Cherwell District Council

**Application no: 23/02098/OUT**

**Proposal: Outline application, with all matters reserved, for a multi-phased (severable), comprehensive residential-led mixed use development comprising: Up to 215,000 square metres gross external area of residential floorspace (or c.1,800 homes which depending on the housing mix could result in a higher or lower number of housing units) within Use Class C3/C4 and large houses of multiple occupation (Sui Generis); Supporting social infrastructure including secondary school/primary school(s) (Use Class F1); health, indoor sport and recreation, emergency and nursery facilities (Class E(d)-(f)). Supporting retail, leisure and community uses, including retail (Class E(a)), cafes and restaurants (Class E(b)), commercial and professional services (Class E(c)), a hotel (Use Class C1), local community uses (Class F2), and other local centre uses within a Sui Generis use including public houses, bars and drinking establishments (including with expanded food provision), hot food takeaways, venues for live music performance, theatre, and cinema. Up to 155,000 net additional square metres (gross external area) of flexible employmen

Policy PR8 – Policies Map – Land East of the A44

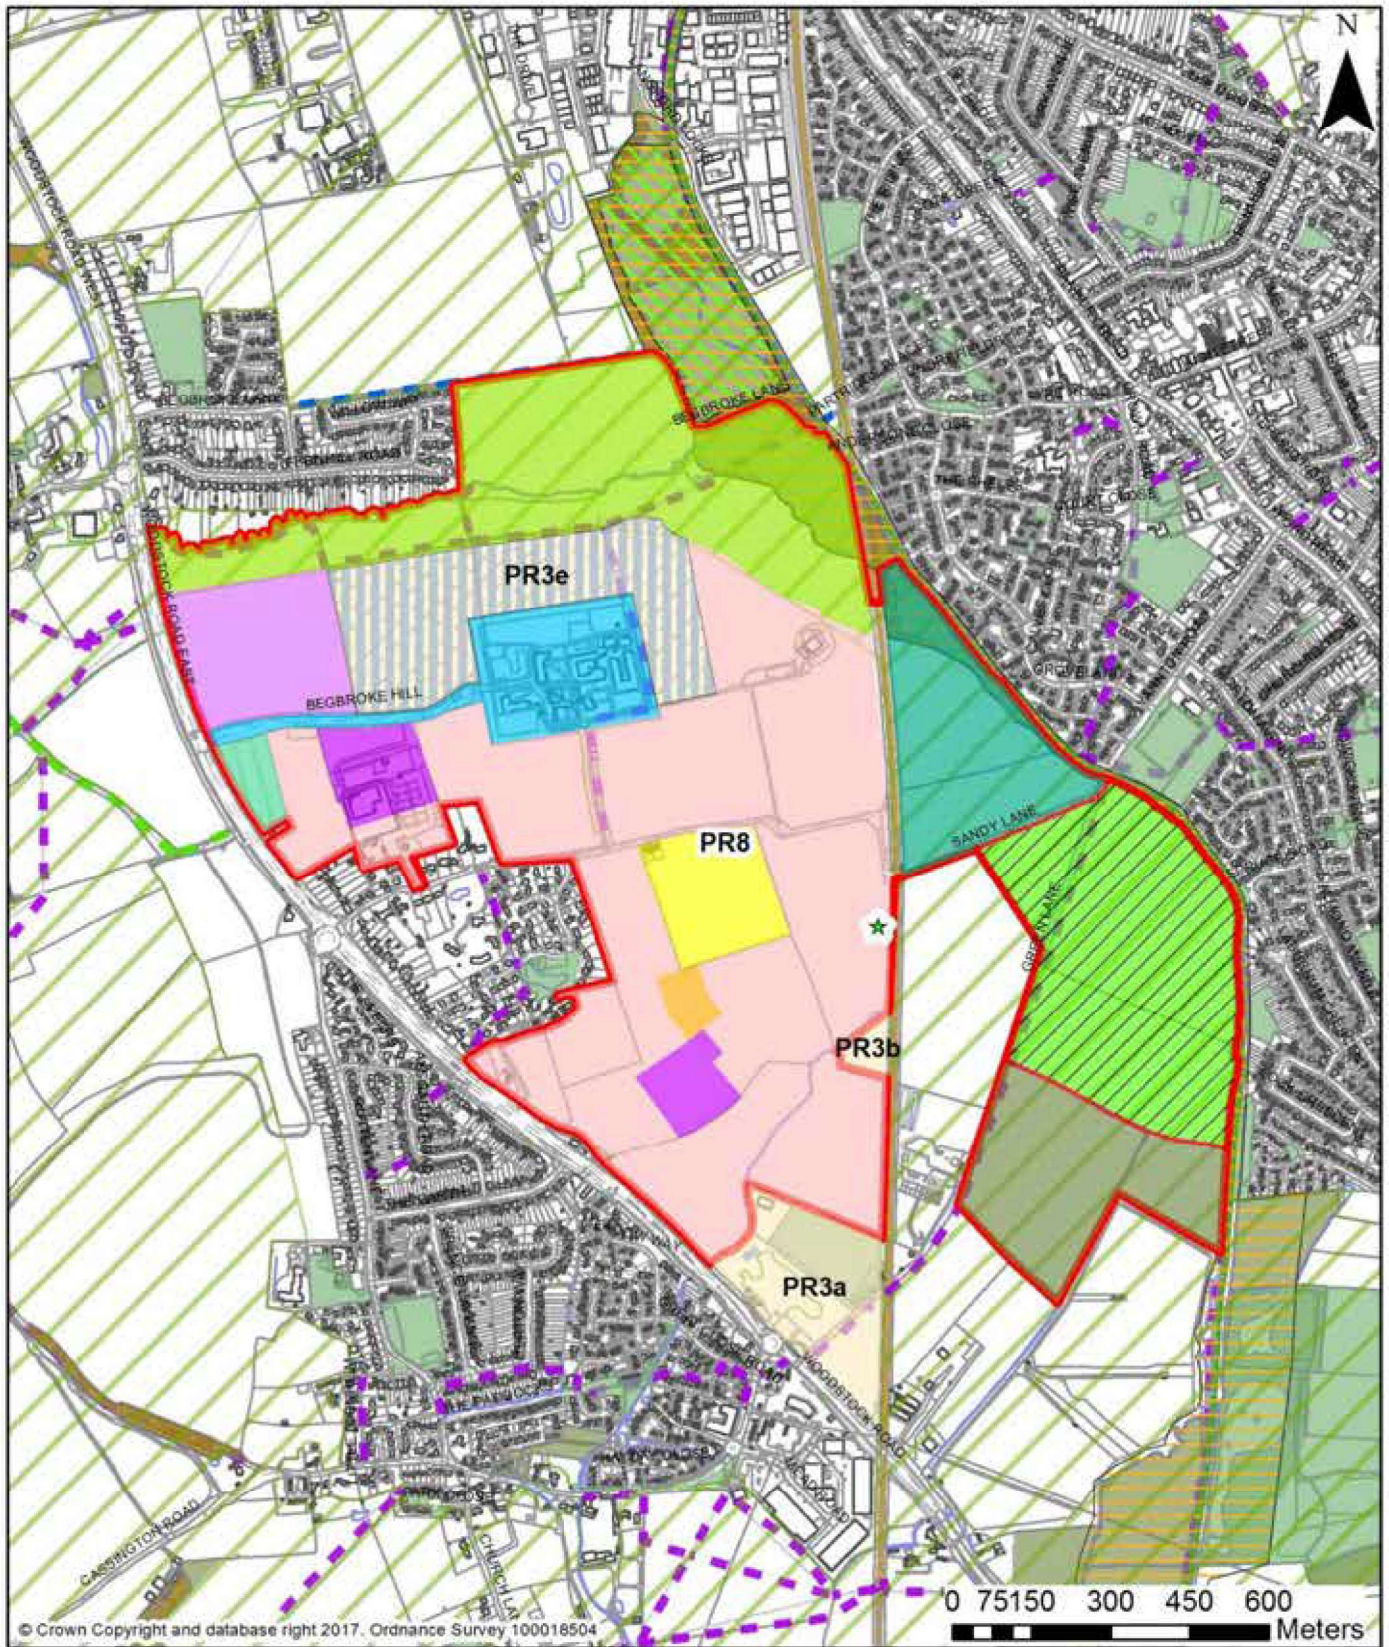
The map titled **Policy PR8 Policies Map – Land East of the A44** indicates the location of the proposed Local Nature Reserve across the northern edge of the development site.

We are very concerned that the current application proposes that the area indicated as a 29ha LNR in the local plan will include a community farm, allotments and a community orchard along with a greatly reduced area for nature which includes a woodland in the west transitioning through wildflower-rich meadows and then wetland and marsh habitats in the east (see Design and Access Statement part 7 5.15). The applicant's Outline Landscape and Ecological Management plan (OLEMP) states (p11):

In conclusion, this application is not delivering a 29.2 ha LNR in the location set out in the Local Plan, and therefore it is not in keeping with the Local Plan policy and should not be approved. The required LNR should be made up of natural habitat, and be managed as a nature reserve, with public access managed and zoned so as to provide an opportunity for people to enjoy a nature reserve without negatively impacting on its wildlife.
